# EL PASO COUNTY

APPLICANT BUILDERS EROSION & STORMWATER QUALITY CONTROL PERMIT (BESQCP)

**DISAPPROVED**  
**Plan Review**  
 07/18/2019 12:43:34 PM  
 dsdarchuleta  
 EPC Planning & Community  
 Development Department

Project Information	
Name and Legal Description	Lot 19 THE TRAILS Fil No. 8
Name of Subdivision Filing	7
Address (or nearest major cross streets)	1 see next page ...UNTER TRL
Acreage (total and disturbed)	2.53 ACRES (50% DISTURBED)
Schedule (start and finish and date of final stabilization)	JUNE 2019 - DECEMBER 2019
Description of Project	CONSTRUCTION OF NEW SINGLE FAMILY HOME
Tax Schedule Number	4217007021

SITE PLAN LOT 19
 SCALE: 1" = 30'-0"

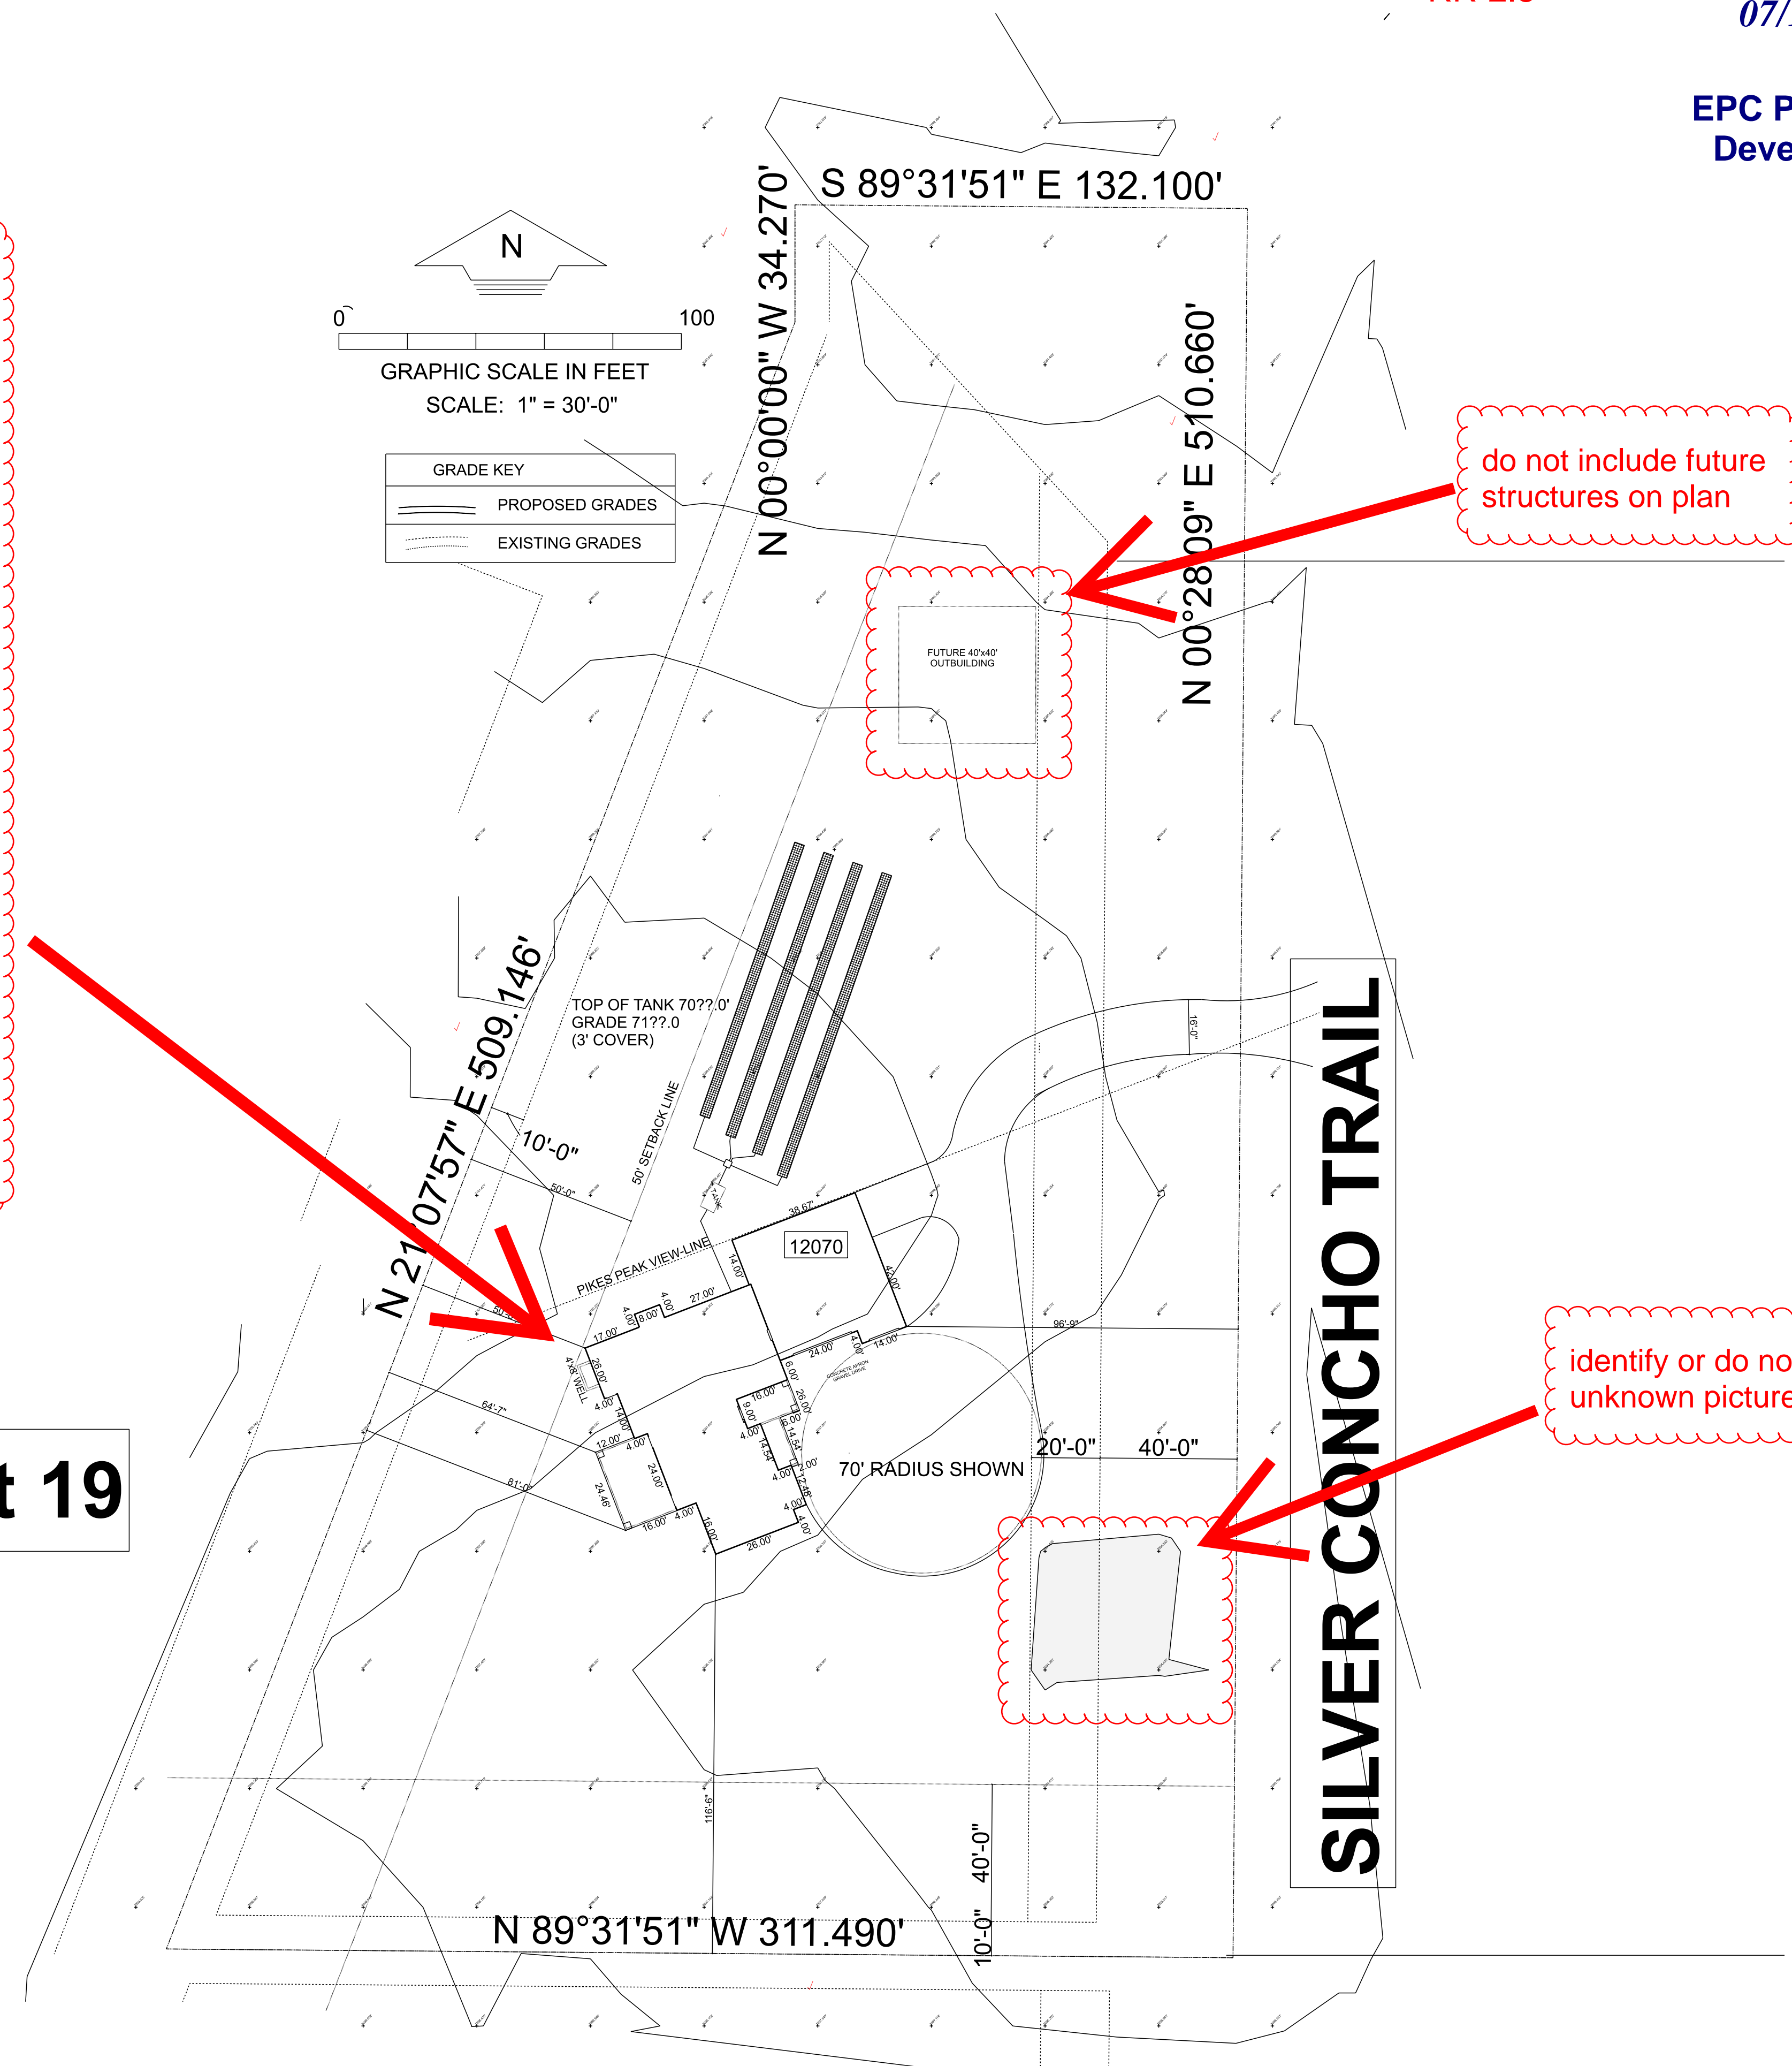
# Imperviousness - rough calculation of area impervious being 1226 sf or 11.12 %

## ESQCP REQUIRED

Single-family residence building site greater/equal 1 acre of land disturbance located on a lot or parcel with the with a total area greater/equal to 2.5 acres or zoned agricultural land and with a proposed total site imperviousness of (10%) up to 20%

## suggestion - reduce the size of the of driveway by 1800 sf
